KIRKLEES METROPOLITAN COUNCIL INVESTMENT & REGENERATION SERVICE

DELEGATED DECISION TO DETERMINE APPLICATIONS FOR CONSENT, AGREEMENT OR APPROVAL REQUIRED BY CONDITION

Reference No:	2025/44/92725/W
Site Address:	adj 67, Chapel Gate, Scholes, Holmfirth, HD9 1SX
Description:	Discharge of details reserved by conditions 7 (CMP), 8 (CEMP), 9 (road condition survey), 14 (invasive non-native species protocol), 15 (footway spec), 17 (road drainage structures), 18 (surface water spec), 19 (exceedance event), 20 (temp drainage) on previous permission 2022/92406 for erection of 10 affordable dwellings with access from Chapelgate and associated works including resident play zone
Recommending Officer:	Ellie Thornhill

Description: Discharge of details reserved by conditions 7 (CMP), 8 (CEMP), 9 (road condition survey), 14 (invasive non-native species protocol), 15 (footway spec), 17 (road drainage structures), 18 (full drainage details), 19 (exceedance event), 20 (temp drainage) on previous permission 2022/92406 for erection of 10 affordable dwellings with access from Chapelgate and associated works including resident play zone

Figure 1: Invasive Plant location plan (*Buddleia davidii* not mapped)

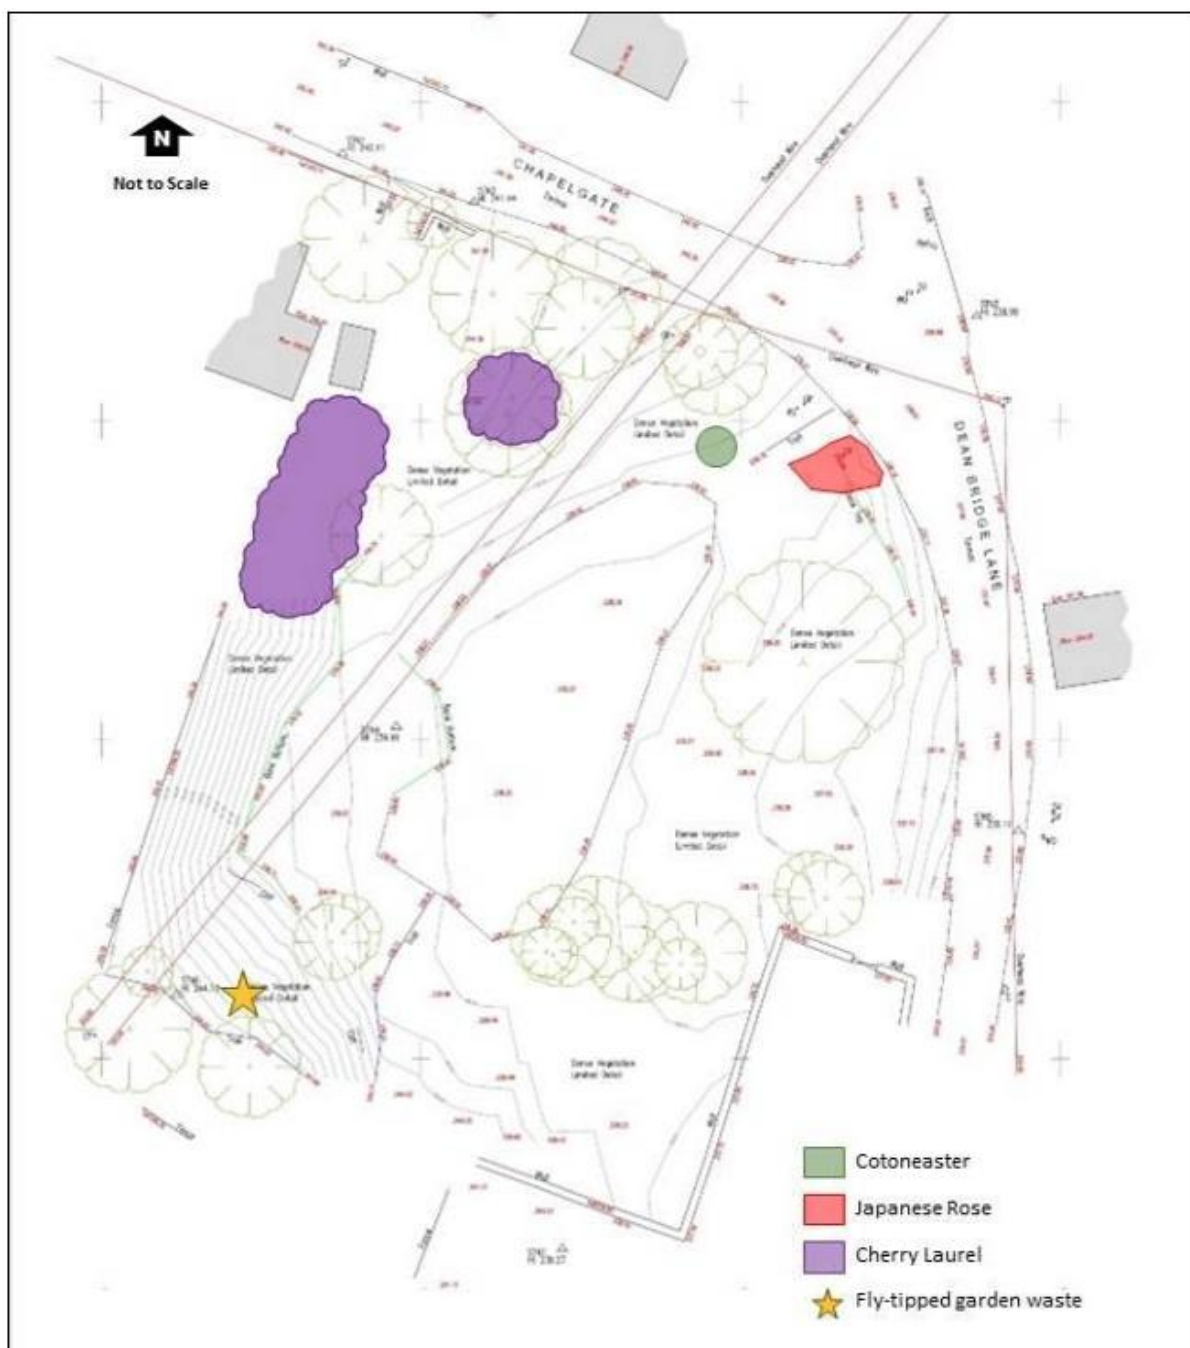
*These species are also acknowledged within page 18 of the EcIA (submitted under 2022/92406) However, the Invasive Plant Management Plan submitted for this application does not include any information in relation to the species "buddleia *Buddleia davidii*", as requested by condition 14.*

*Therefore, in the absence of this information a full assessment of condition 14 cannot be undertaken at this time and therefore, the Invasive Plant Management Plan should be updated/revised to include this specie. Should "buddleia *Buddleia davidii*" no longer be present at the site, an explanation as to why, would be required.*

The revised report identifies the measures that will be implemented to contain, treat and eradicate the invasive species recorded within the site, including the previously omitted *buddleia Buddleia davidii*, thereby preventing any further spread. The report further confirms that the off-site disposal of invasive plant

Therefore, it is considered that the information submitted is now acceptable to support the discharge of condition 14.
